Memorandum

To: Carmen Moran
CC: Nancy Cline, Aaron Russell
From: Clay Barnett
Date: 8/15/2007
Re: Goldfarb Addition

**REPLAT**  
of  
Lot 12R, Block 90  
Goldfarb Addition  
1.991 acres out of the  
Allen Bledsoe Survey, Abstract No. 157  
City of Addison  
Dallas County, Texas  
-- August 2007 --

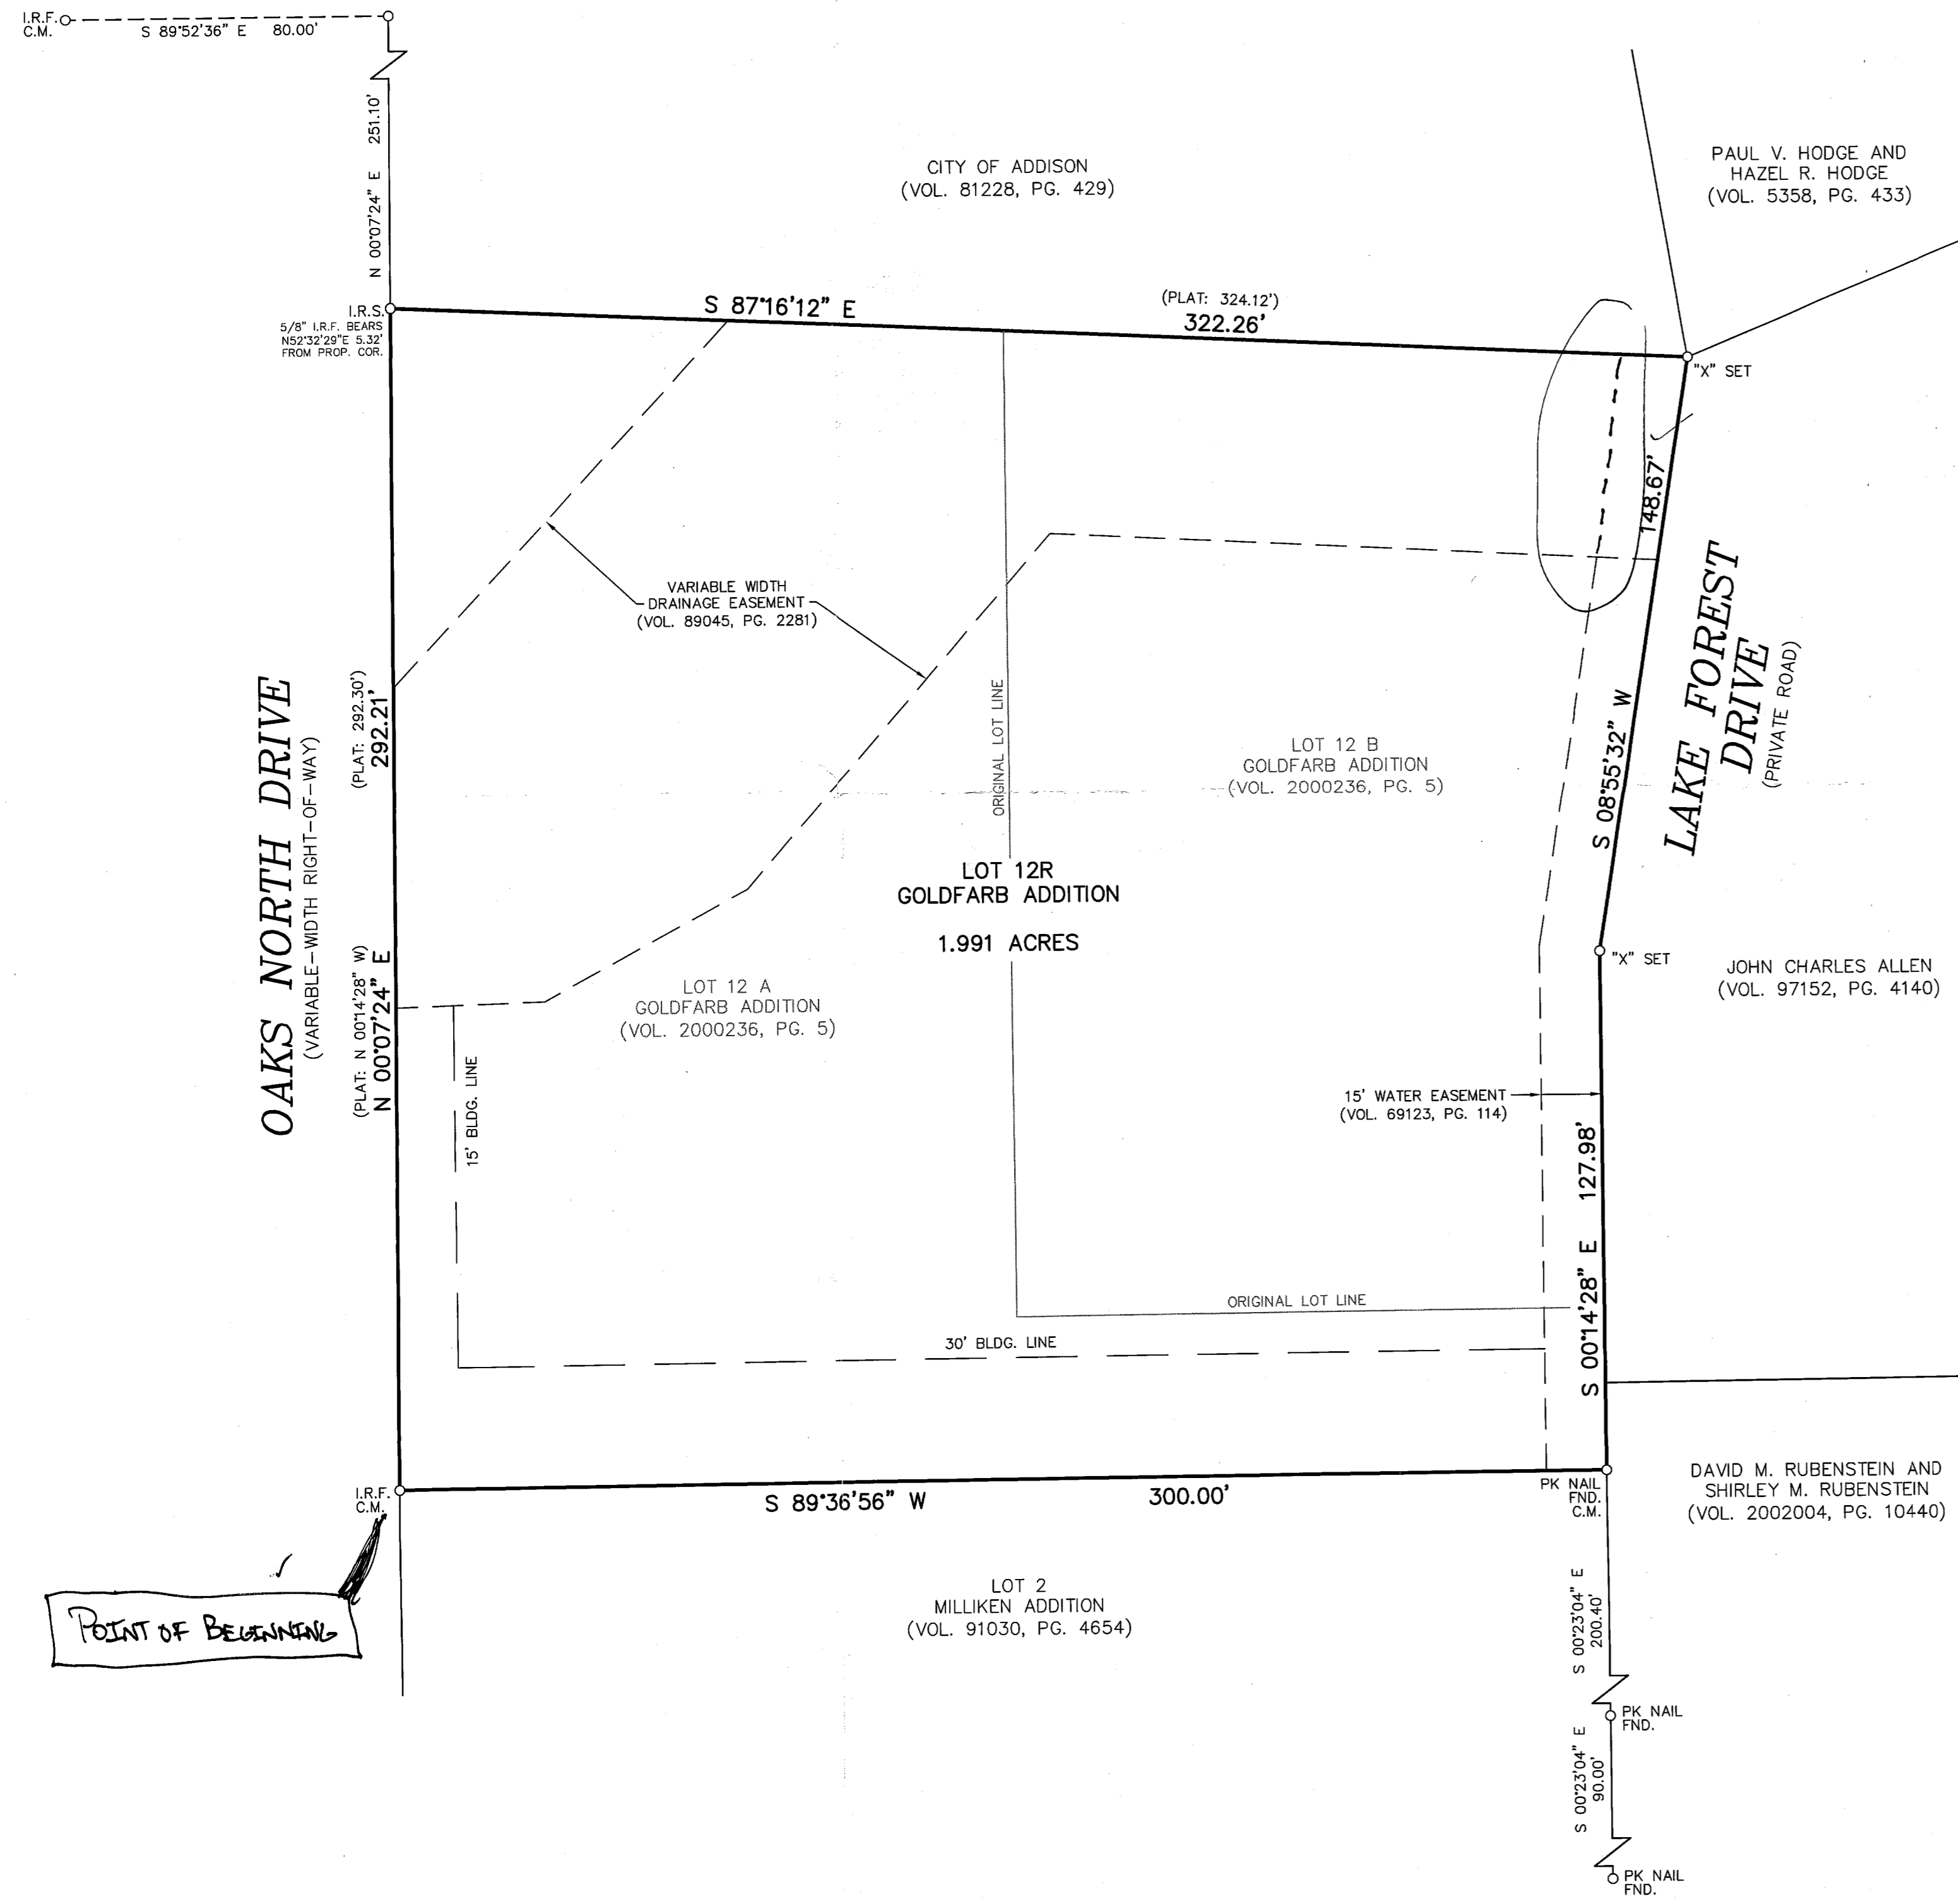
-
1. Indicate the "POINT OF BEGINNING" on the face of the plat.
 2. The 15' Water Easement along the east property line should extend to the north property line.
 3. Add a 25' private street easement along the east property line for Lake Forest Drive.
 4. Add a signature block for the mayor and city secretary.
 5. Remove all building lines.
 6. Remove Note 3 (flood statement) from the plat.
 7. Add a signature block for the notary under the surveyor's certification.
 8. The first paragraph of the dedication statement does not match the Town Ordinances. Please revise.
 9. Change all references of the "City of Addison" to the "Town of Addison".
 10. Submit a closure sheet.
